CITY OF ALBUQUERQUE

May 11, 2015

**RE: Main Event, Pan American Freeway and Vassar Drive
Grading Plan and Drainage Plan
Engineer's Stamp Date 5-07-2015 (File: G16-D149)**

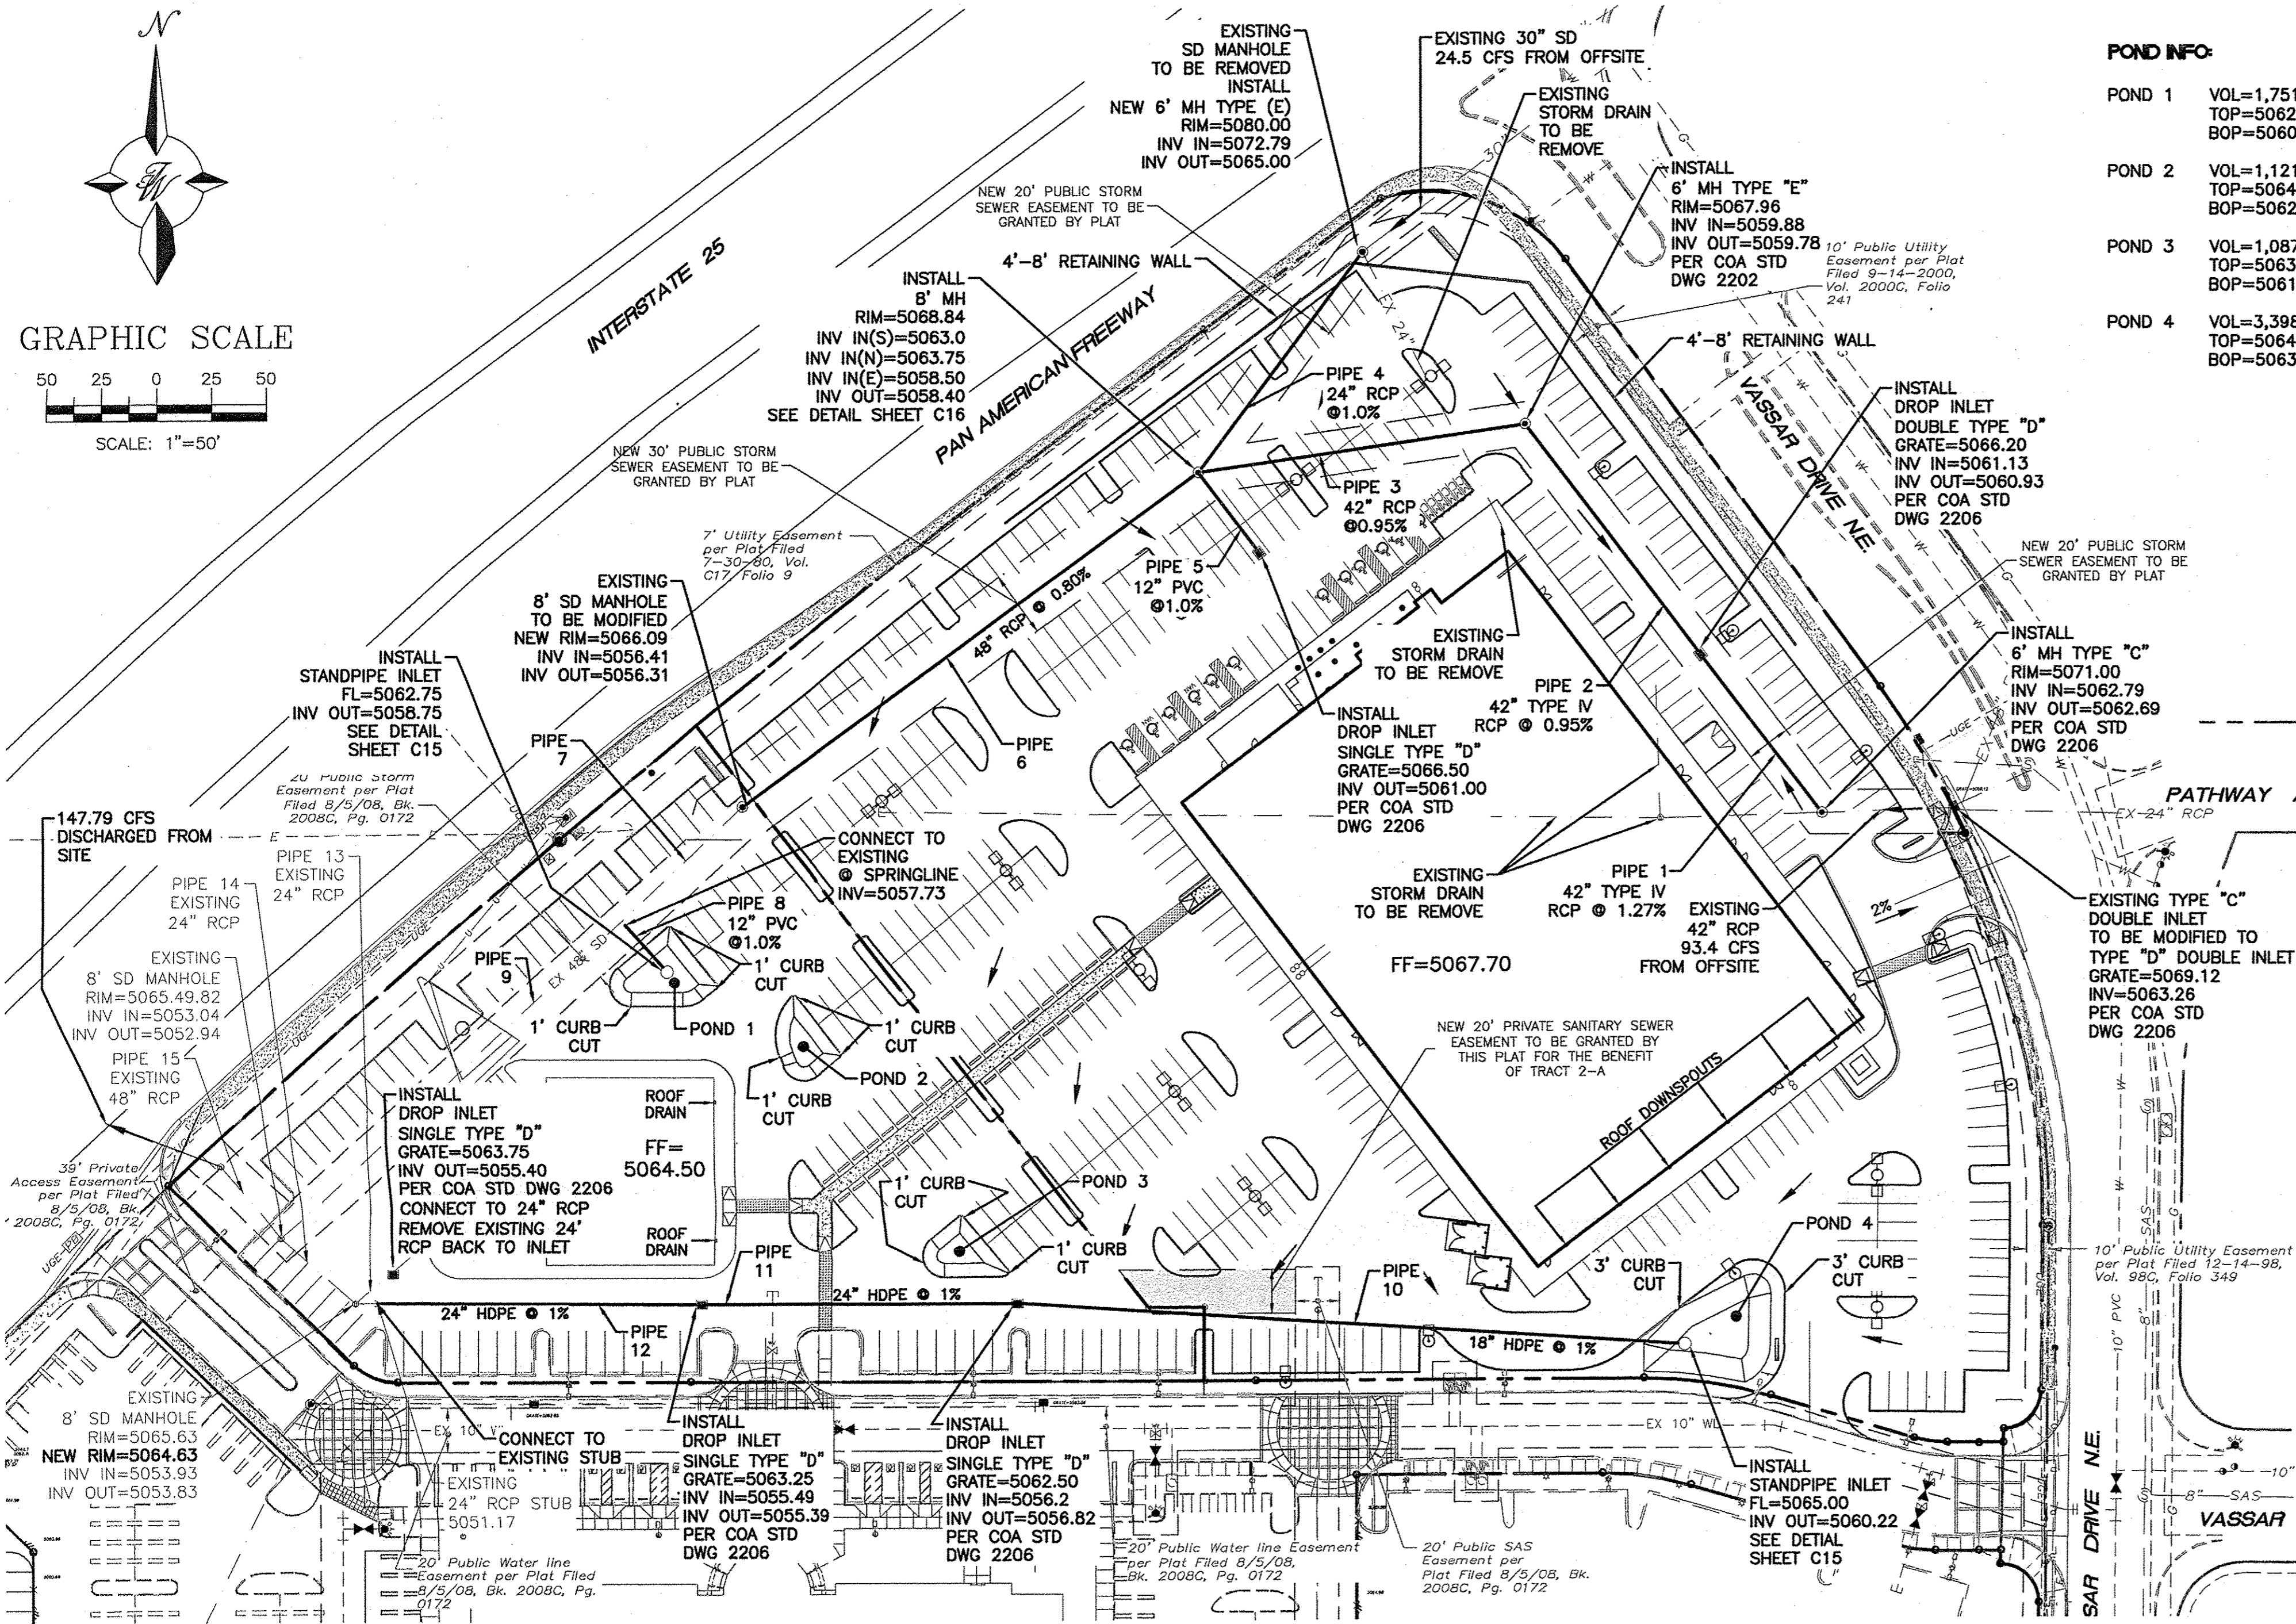
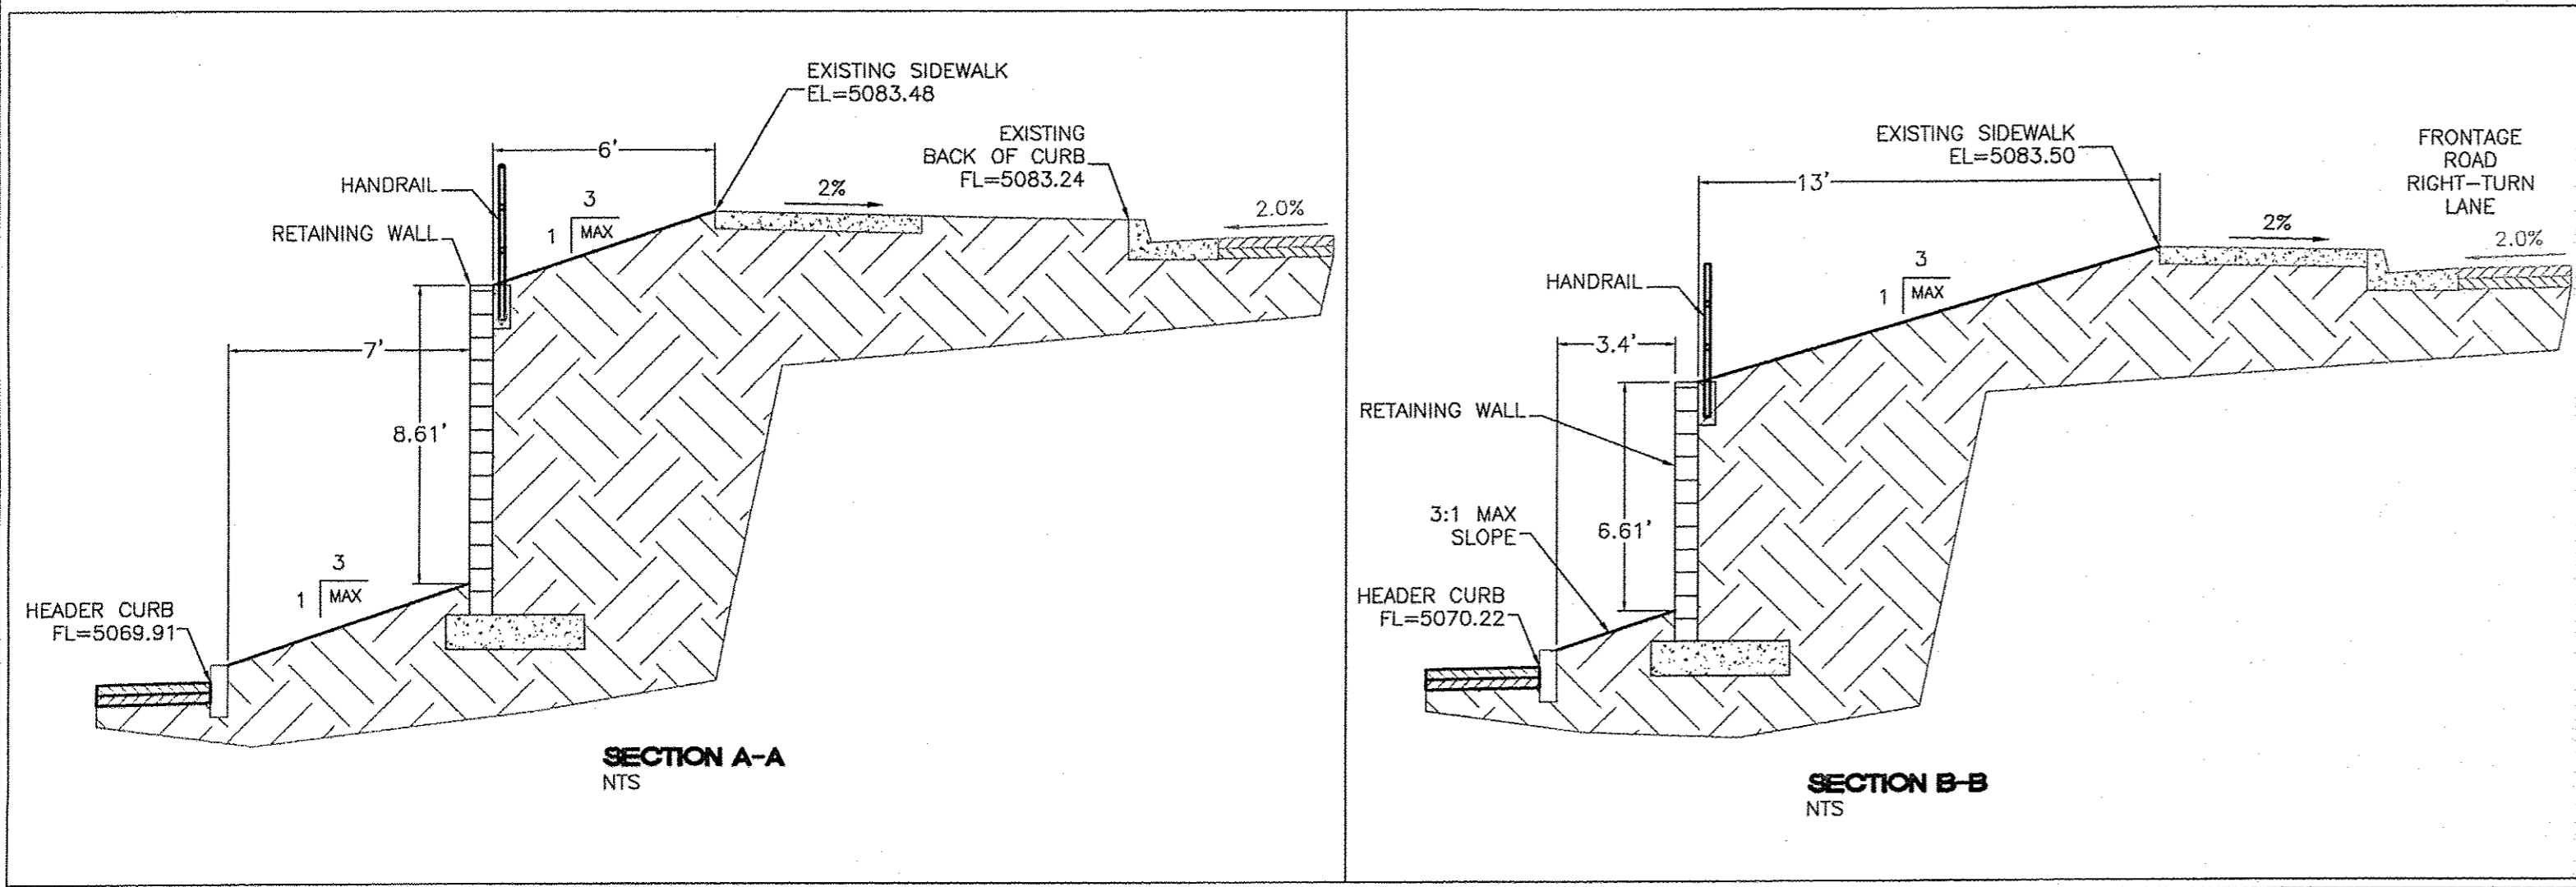
- 1) Label the individual volumes for each of the first flush pond areas, and show spot elevations and contours to demonstrate retention of the required first flush volumes.
- 2) Provide curb cut capacity calculations as applicable for these ponding areas.
